Planning Application: 391 St Albans Road West Hatfield Hertfordshire AL10 9RU

Major Objection:

Purpose of Issue: **PLANNING** Job No. **2011**
 MRS GLORIA ROWLAND
 Home Extension
 391 St Albans Road West, Hatfield, AL10 9RU
 Garden Apartments
 Proposed Ground Floor Plan

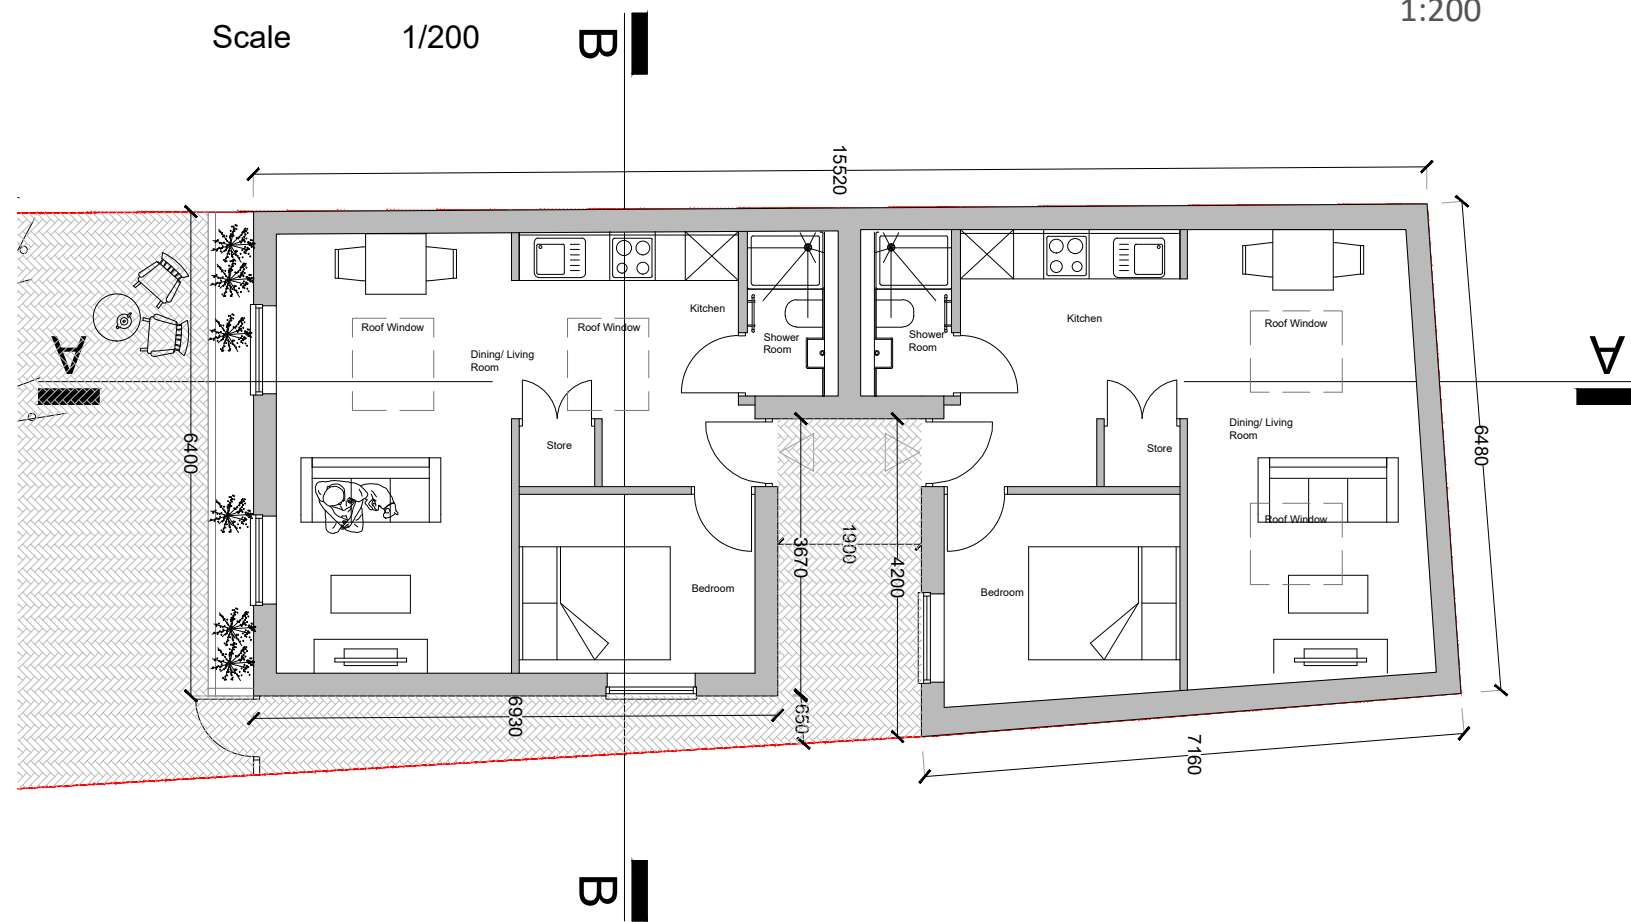
The Town Council do not have objections to the proposed garage conversion or house extension being proposed as part of this planning application, although we note that these would reduce the gap between the property with its neighbour. However, the development of two separate garden apartments at the bottom of the garden are inappropriate and **should officers be minded to grant planning permission we would like to raise a major objection** on the basis of the following points:

- 2) Should the developers wish to reclassify the garden apartments as independent dwelling, the Town Council would object to the development on the grounds that there is no independent access to the properties.

- 3) In both cases we do not believe that the development is an example of good design due to the access (or lack thereof) proposed. Paragraphs 112 and 167 of the NPPF state clearly that developers must consider the access for the delivery of services and for the emergency services. If these garden apartments are for elderly relatives, it is even more important that access to them is quick and easy. It is unclear how paramedics or fire fighters would access the properties without first going through the main house, and there is no vehicle access. This is a significant issue given the presence of two kitchens. Furthermore, there does not seem to be a sensible escape route from the garden apartments should an emergency occur in the main house, and in addition no sensible escape route for the second garden apartment (the one furthest from the house) should the first garden apartment suffer a fire or similar emergency.
